**Director General's Requirements
Kooragang Island Bulk Liquids Storage Facility Project
Project Application No: 07_0044**

**Project Application 07_0044 - Request for Key Issues and Assessment Requirements
Proposed Construction and Operation of a Bulk Liquids Storage Facility
Lots 1 to 4 DP 234887 Greenleaf Road, Kooragang Island**

**RE: PROPOSED BULK LIQUIDS STORAGE FACILITY FOR THE RECEIVAL,
STORAGE, BLENDING AND DISTRIBUTION OF HIGH QUALITY FUELS AND
BIOFUELS
PROPERTIES: 4 & 6 GREENLEAF ROAD KOORAGANG**

REQUEST FOR PROVISION OF DETAILS OF KEY ISSUES AND ASSESSMENT REQUIREMENTS – BULK LIQUIDS STORAGE FACILITY, GREENLEAF ROAD KOORAGANG ISLAND

Figure 3
Site Plan
Environmental Assessment - Bulk Liquids Storage Facility
Greenleaf Road Kooragang Island

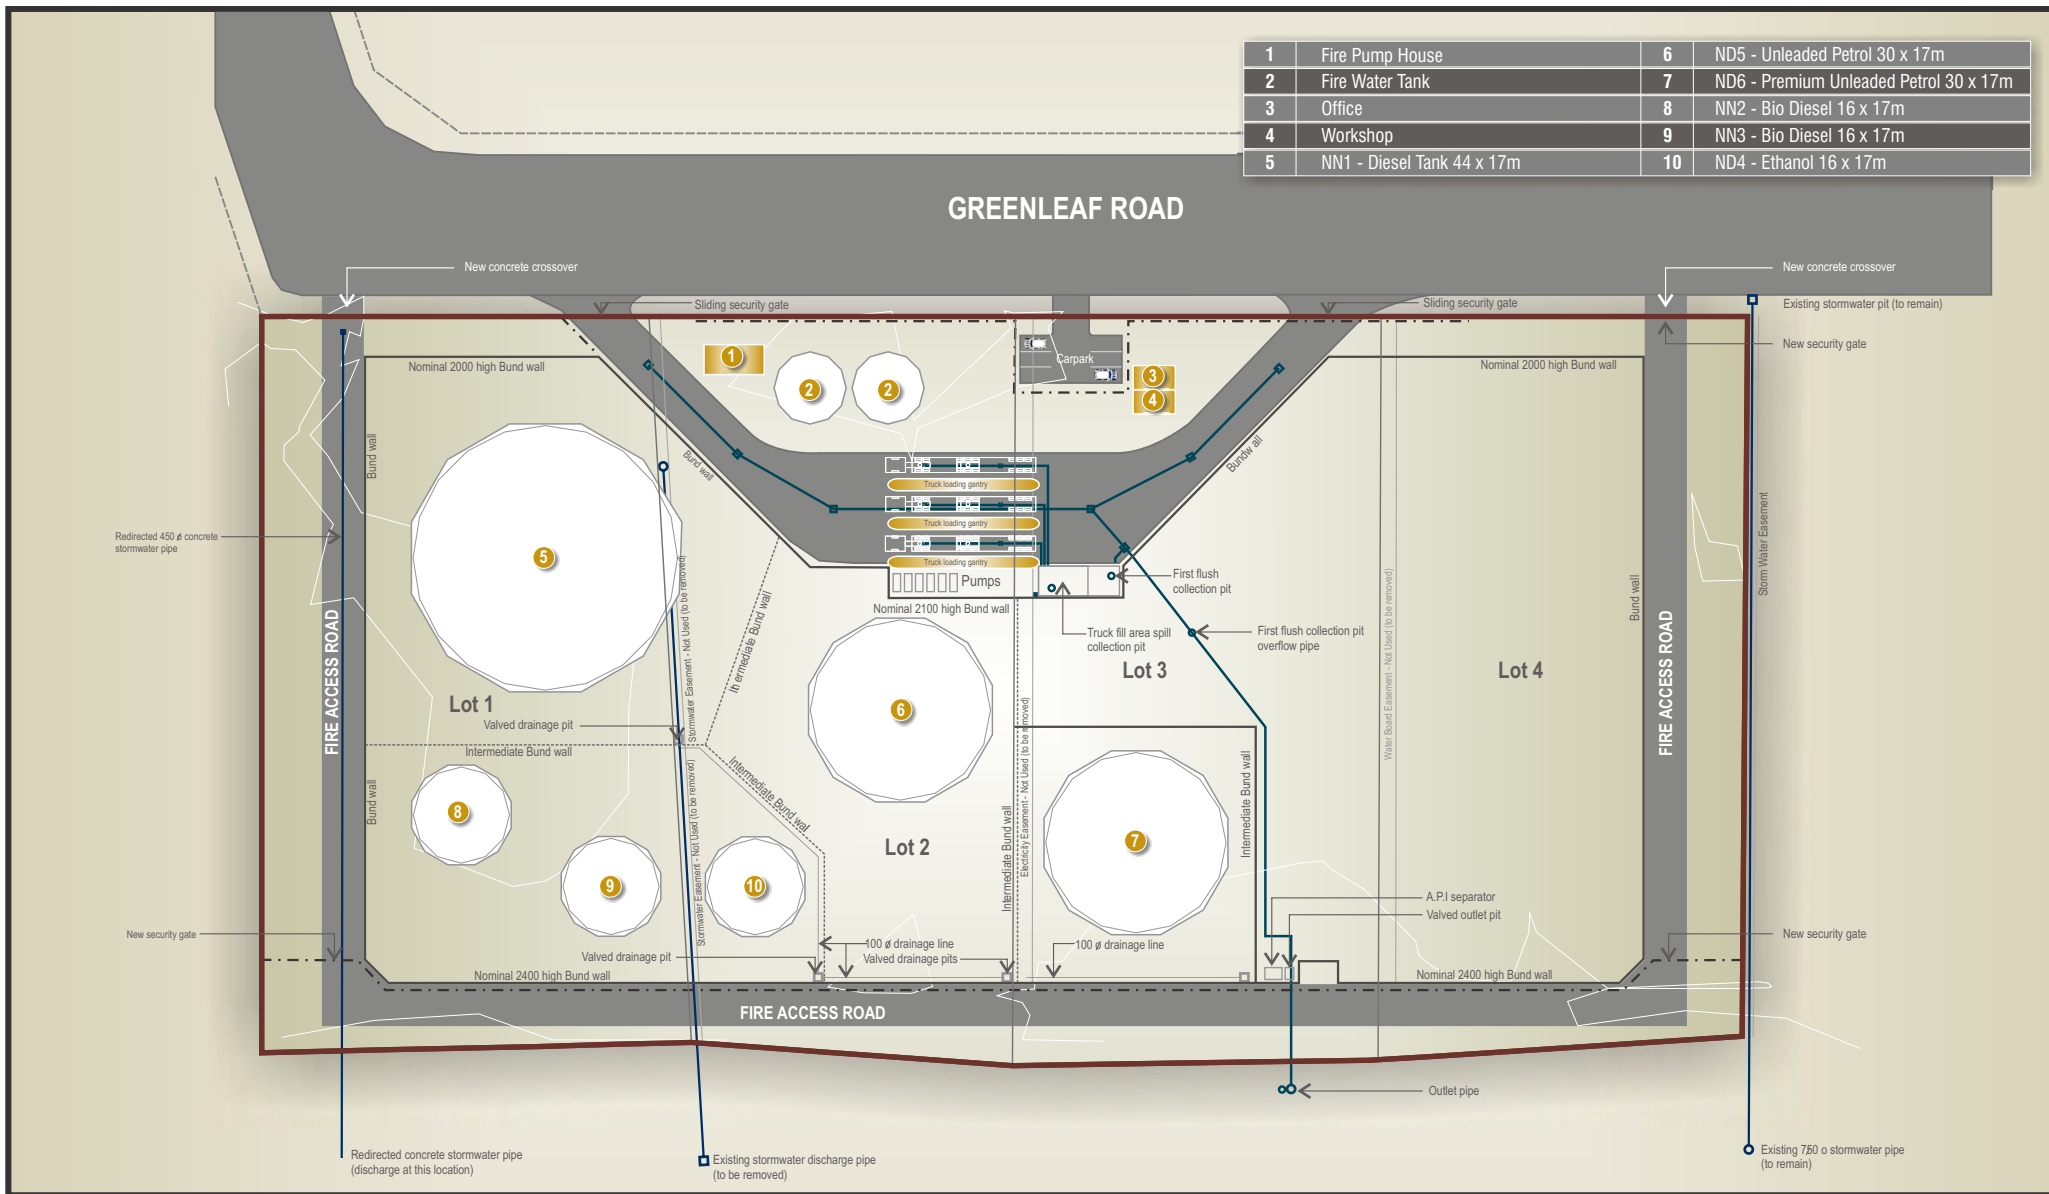
Demonstrate compliance with the relevant requirements of the Newcastle Development Control Plan 2005. In this regard, the proposed carparking layout indicated on the site plan F3 is not satisfactory.
